## Application for a Non-Material Amendment Following a Grant of Planning Permission

22/00349/FULL | Construction of a detached dwelling with associated landscaping and parking, refuse and cycle storage and widening of existing access, following demolition of existing building. | 20 Pelling Hill Old Windsor Windsor SL4 2LL

Rendered wall finish to replace stone wall finish to certain walls  
Windows with mullions to the Rear Elevation.

Site Location :	20 Pelling Hill, Old Windsor SL4 2LL
Project Name :	New Eco Dwelling
Drawing Name :	Proposed Elevations
Drawing No:	220-P003S Scales : 1:100, 1:200
Date :	18 January 2024

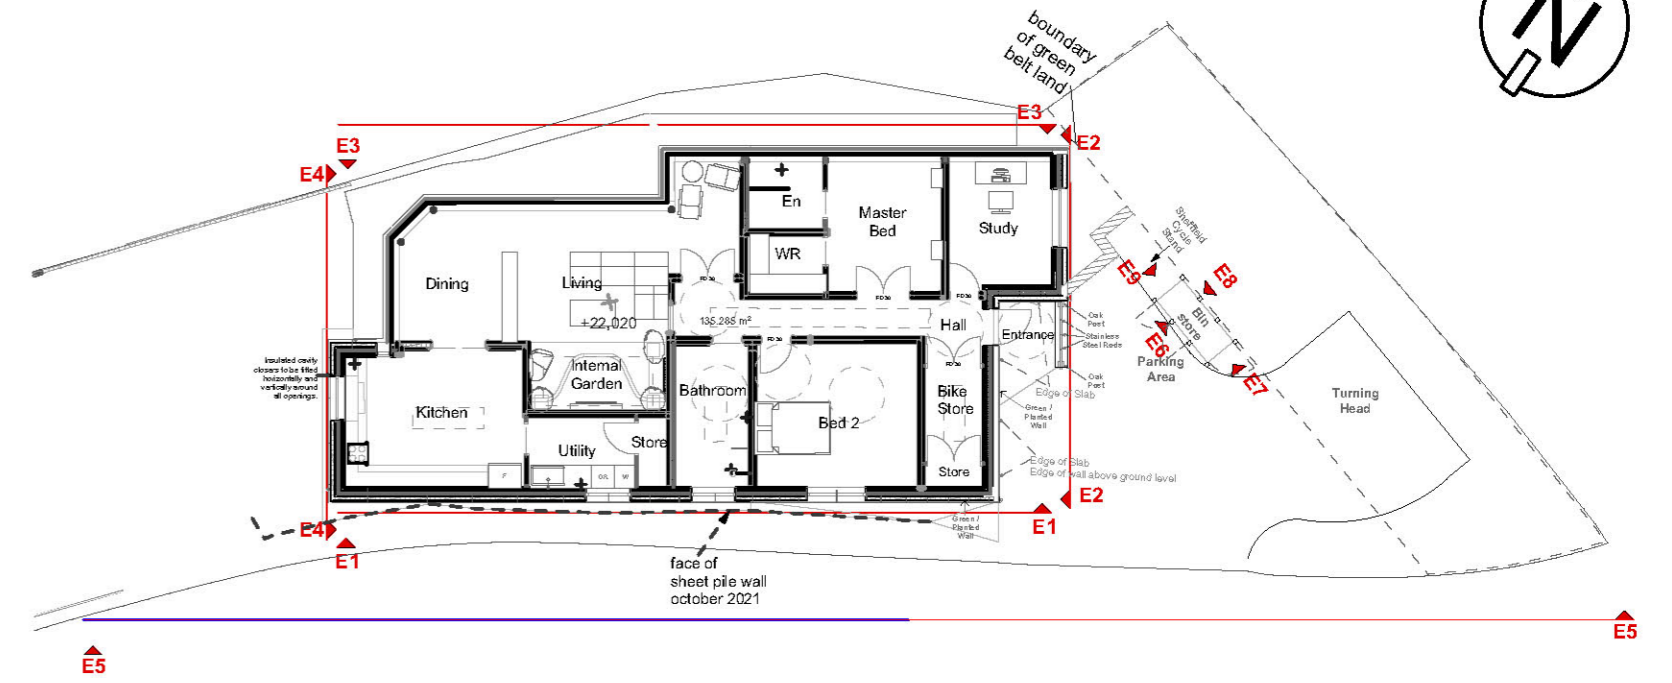
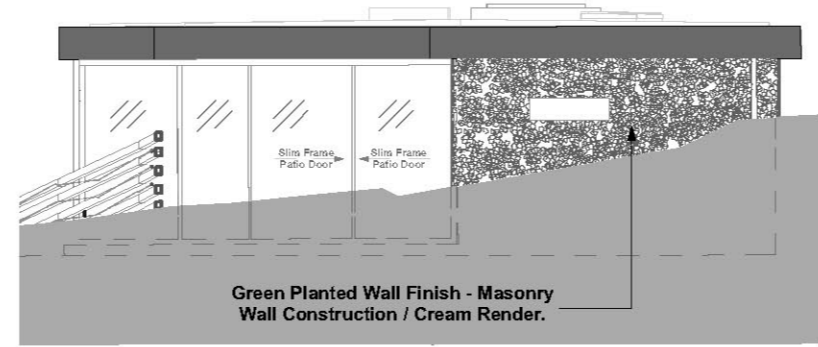
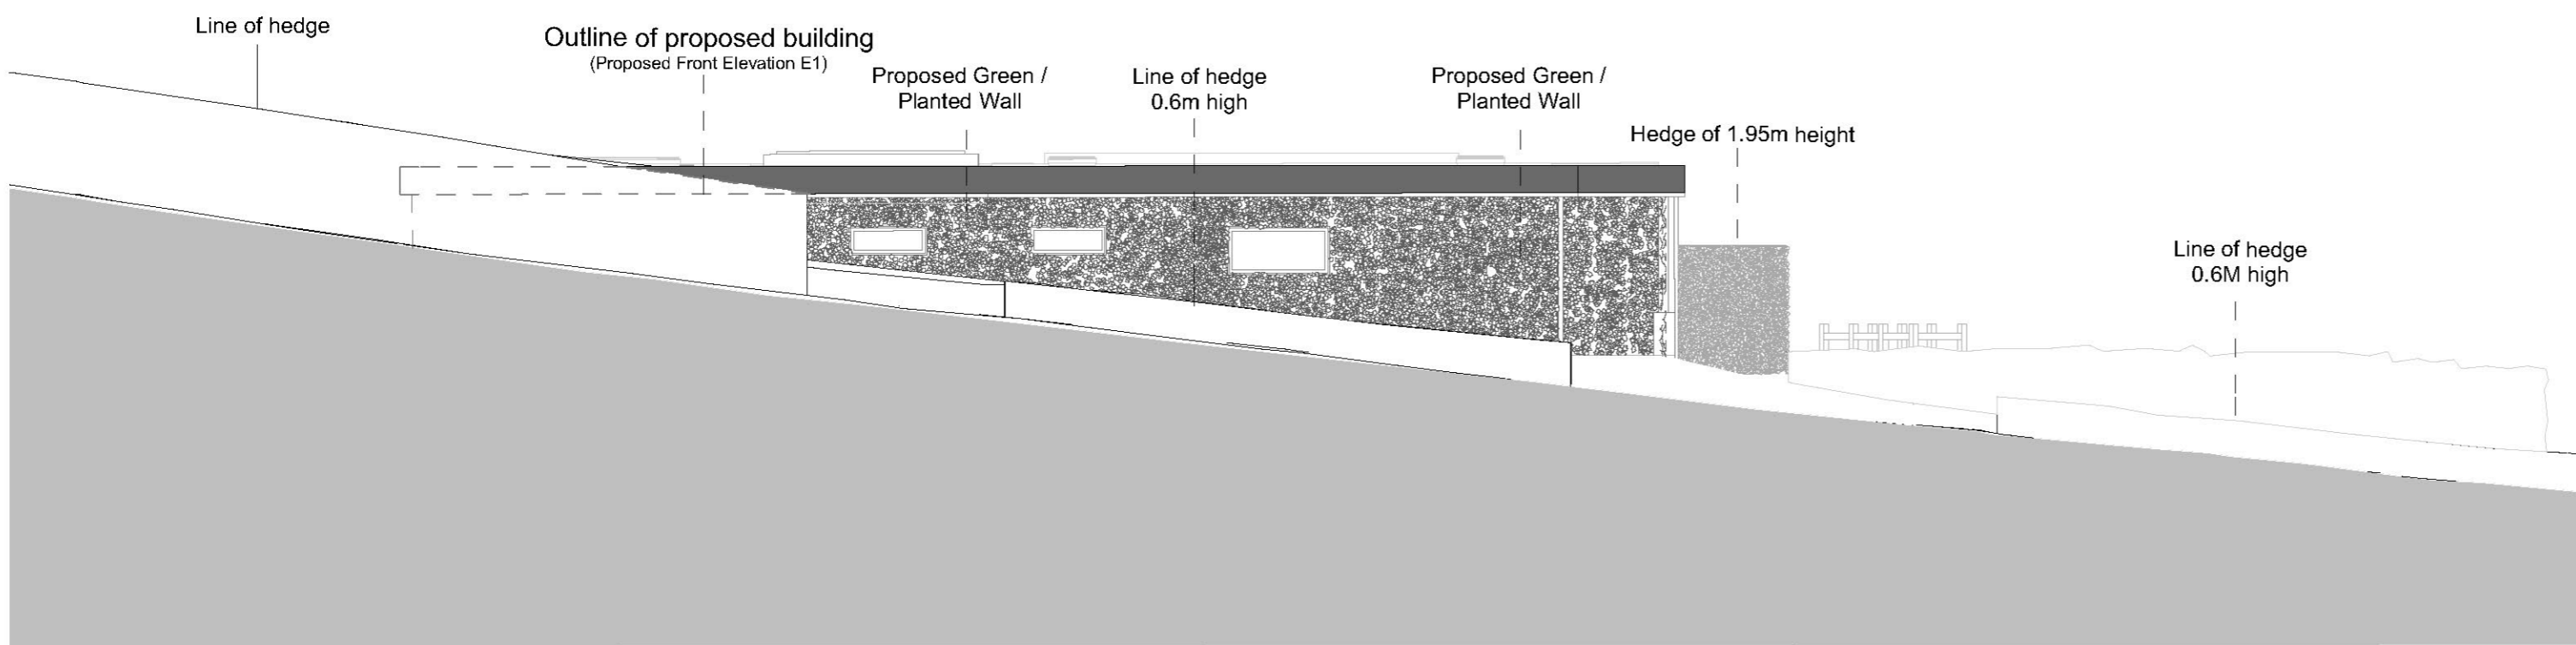
Window mullions to allow openable windows for natural ventilation. Render to improve waterproofing for the walls and for cost feasibility. Aesthetic of green planted wall is still retained. The tone of the rendered wall will complement the tone of the stone wall.

220-P001X  
220-P003S  
220-P008L  
220-P501
